COMMUNITY DEVELOPMENT DEPARTMENT
501 Delta Avenue ♦ Marysville, WA 98270 ♦ (360) 363-8000

February 23, 2024

Re: Kendall Auto Group Auto Storage Yard – *Technical Review 2*
PA 23020

CORNER SHEET  
**C1.0**

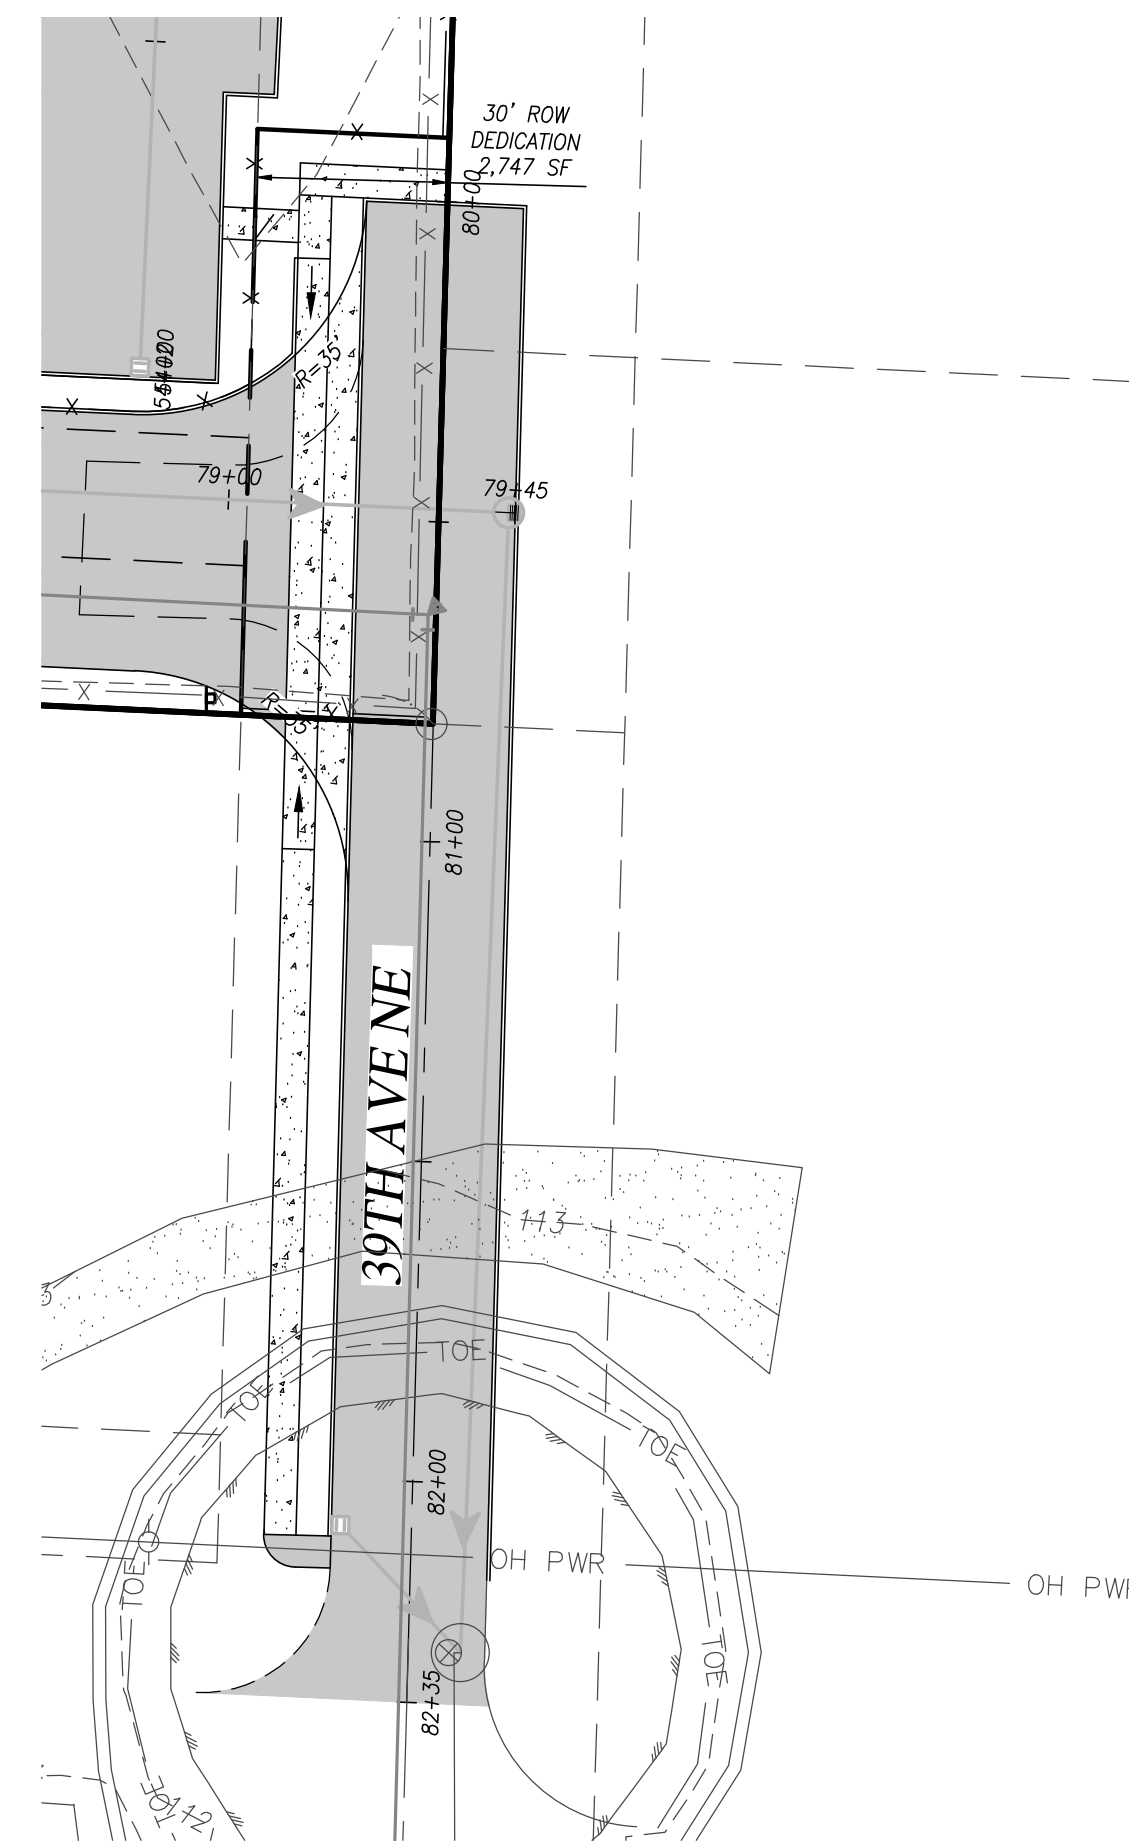
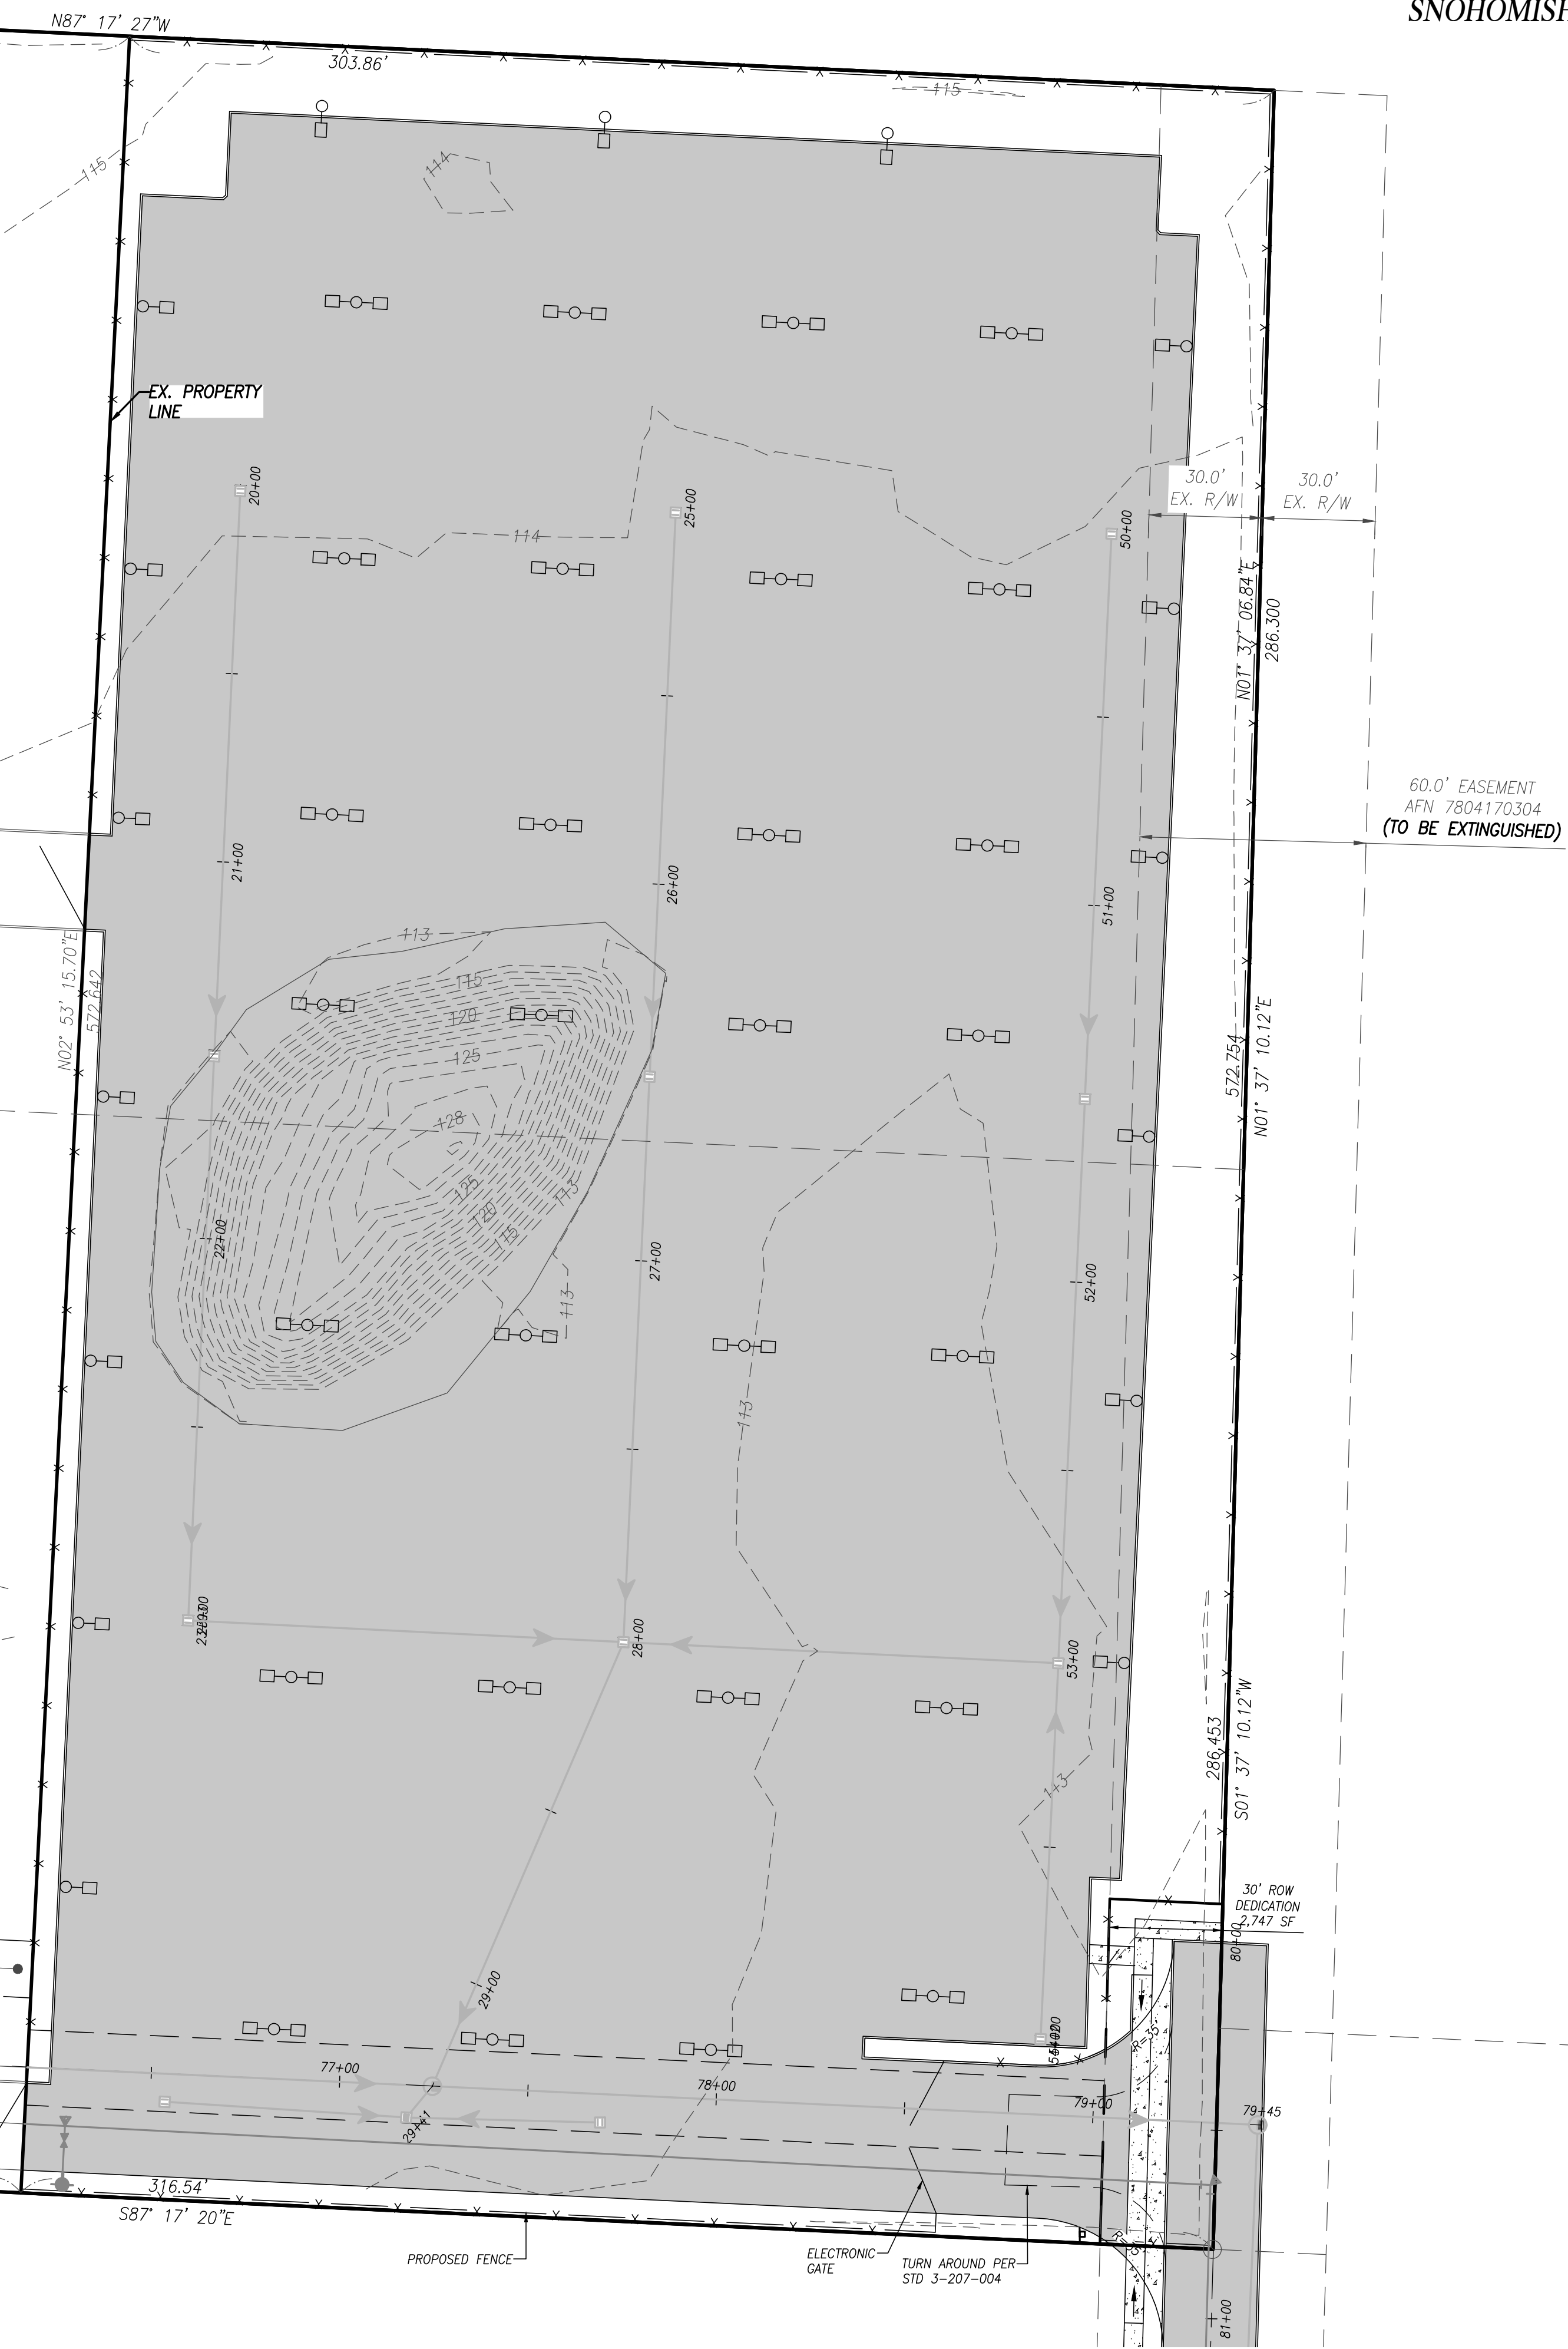
2. The site plan shall be amended, as follows:
 - a. **TR1 Comment:** Provide impervious surface calculations demonstrating compliance with the 85% maximum impervious surface allowance.
TR2 Response: Please review to impervious surface calculations on C1.
TR2 Response: Impervious surface calculations are not provided on Sheet C1.

EXISTING FEATURES MAP

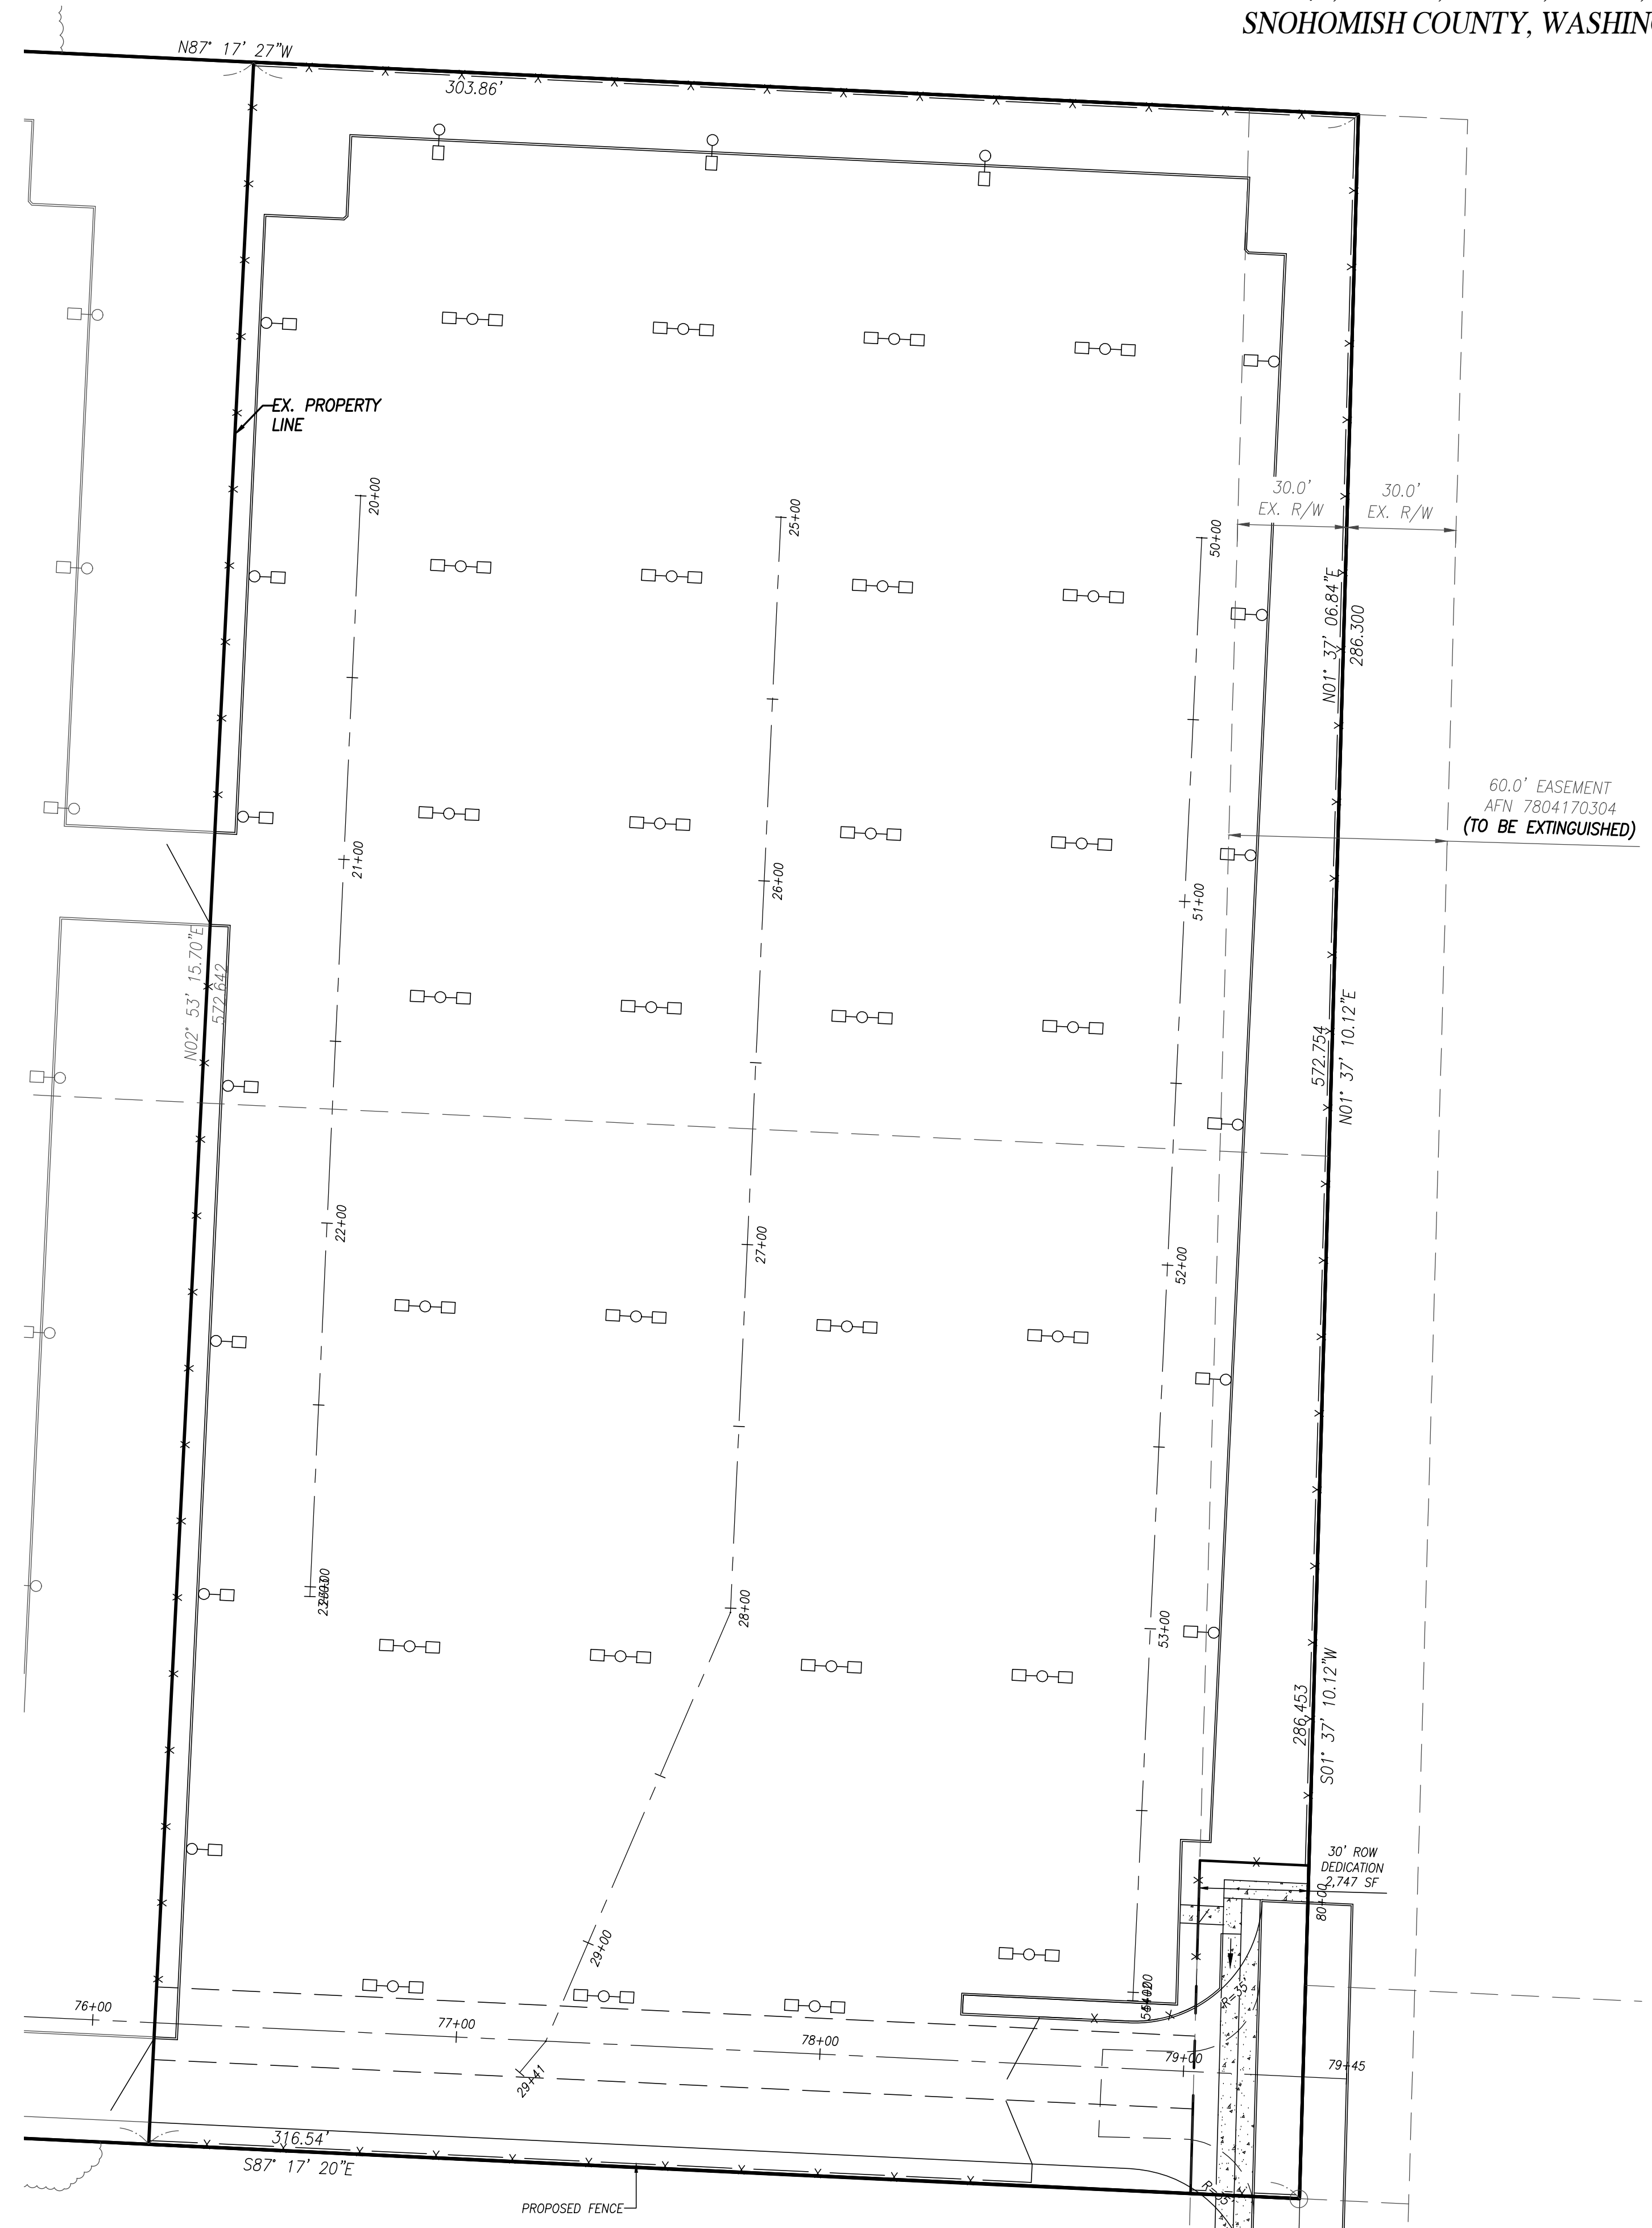
1. **TR1 Comment:** Amend sheets S1 and C1.1 to depict all encumbrances outlined in Schedule B of the Title Report prepared by Chicago Title Insurance Company, dated July 25, 2023. If the encumbrances cannot be depicted then they will need to be referenced.
TR1 Response: Encumbrances have been depicted onsite. Those that have not been depicted a merely referenced.
TR2 Response: In review of the title report there are number of easements that have not been depicted, and have not been referenced on Sheets S1 and C1.1 (i.e. AFN 201706210438, 201907310731 & 202306150110).
